**WRITTEN SUBMISSIONS OF NFU AND LIG REGARDING THE NORFOLK BOREAS OFFSHORE
WINDFARM PROJECT CONSENT ORDER 201 [...]**

PLANNING INSPECTORATE REFERENCE NO EN010087

**SUBMISSIONS OF NATIONAL FARMERS UNION AND THE LAND INTEREST GROUP AT THE –
NECTON AREA OPEN FLOOR HEARING ON 15 JULY 2020**

DATE 29TH JULY 2020

Cut Line sheet 42
Cut Line sheet 40

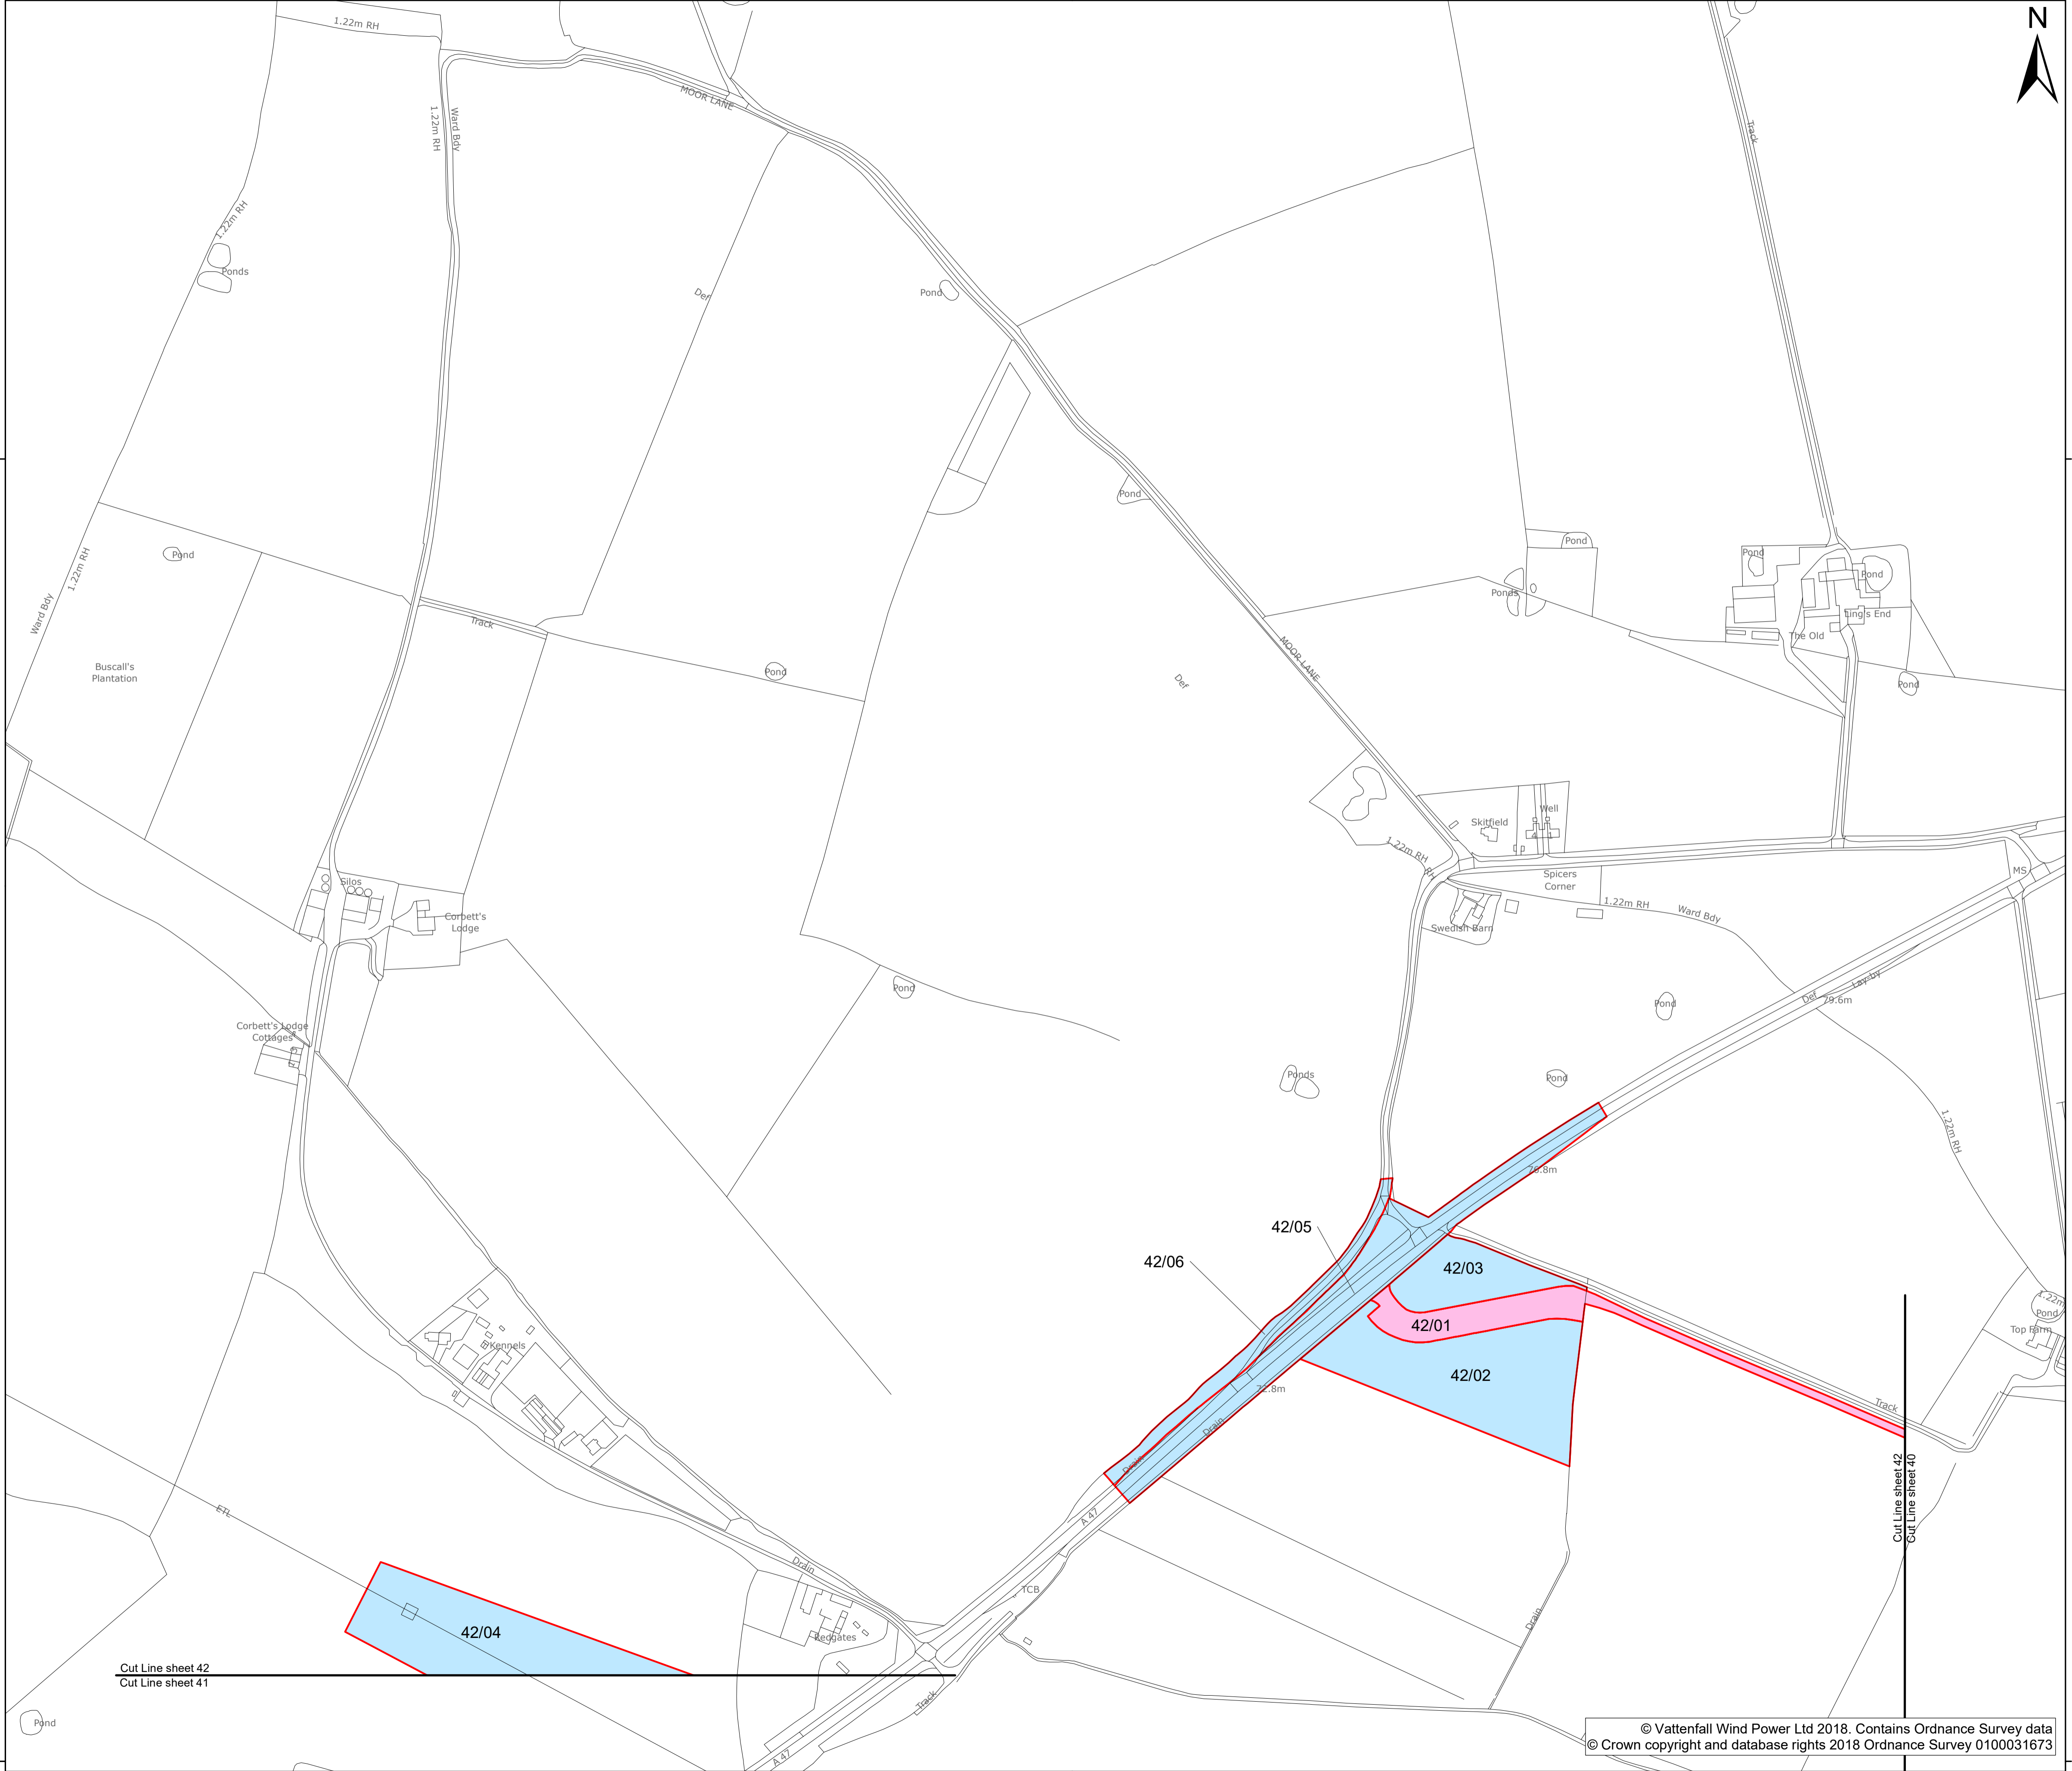
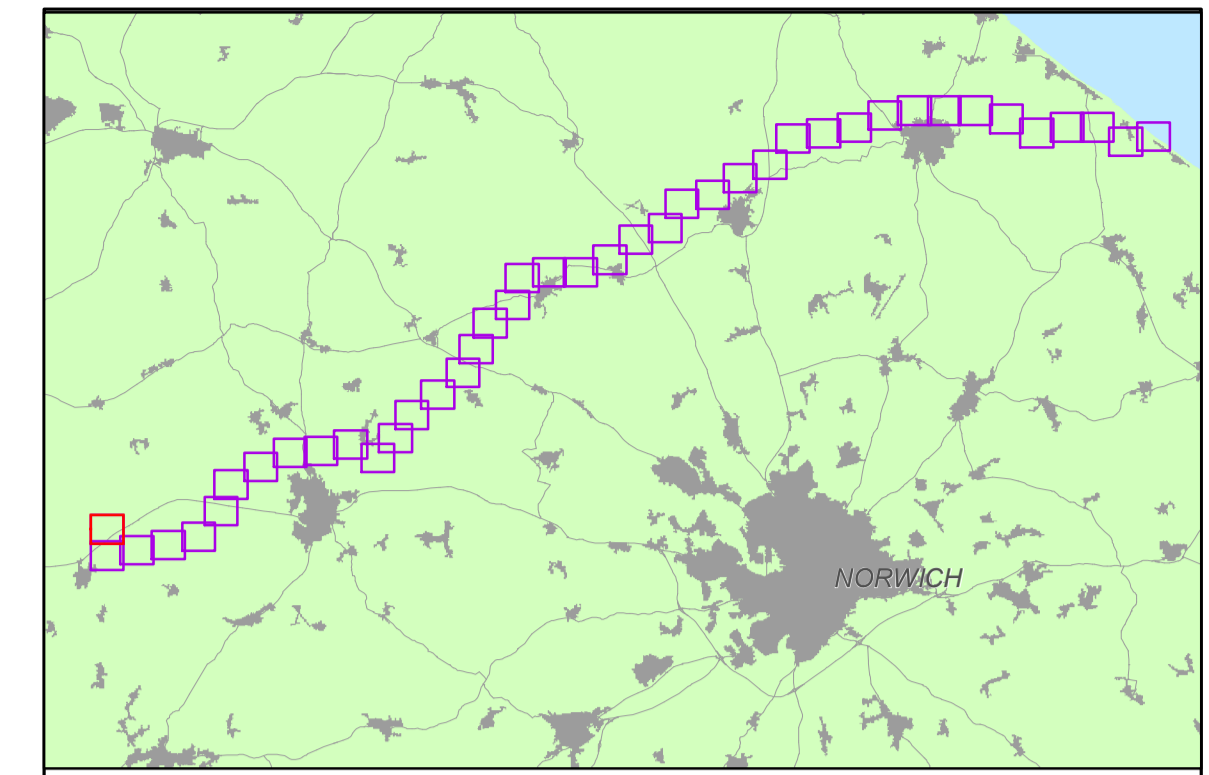
The red line boundary of the land required for the Boreas substation prevents the Landowner effected by the substation to be able to gain access to other land within the Estate ownership. Provision needs to be made within the DCO for suitable access to be provided. Please see the attached plan indicating where the location of the access is required circled in green. This access needs to be a minimum width of 12 metres to allow for agricultural machinery to pass.
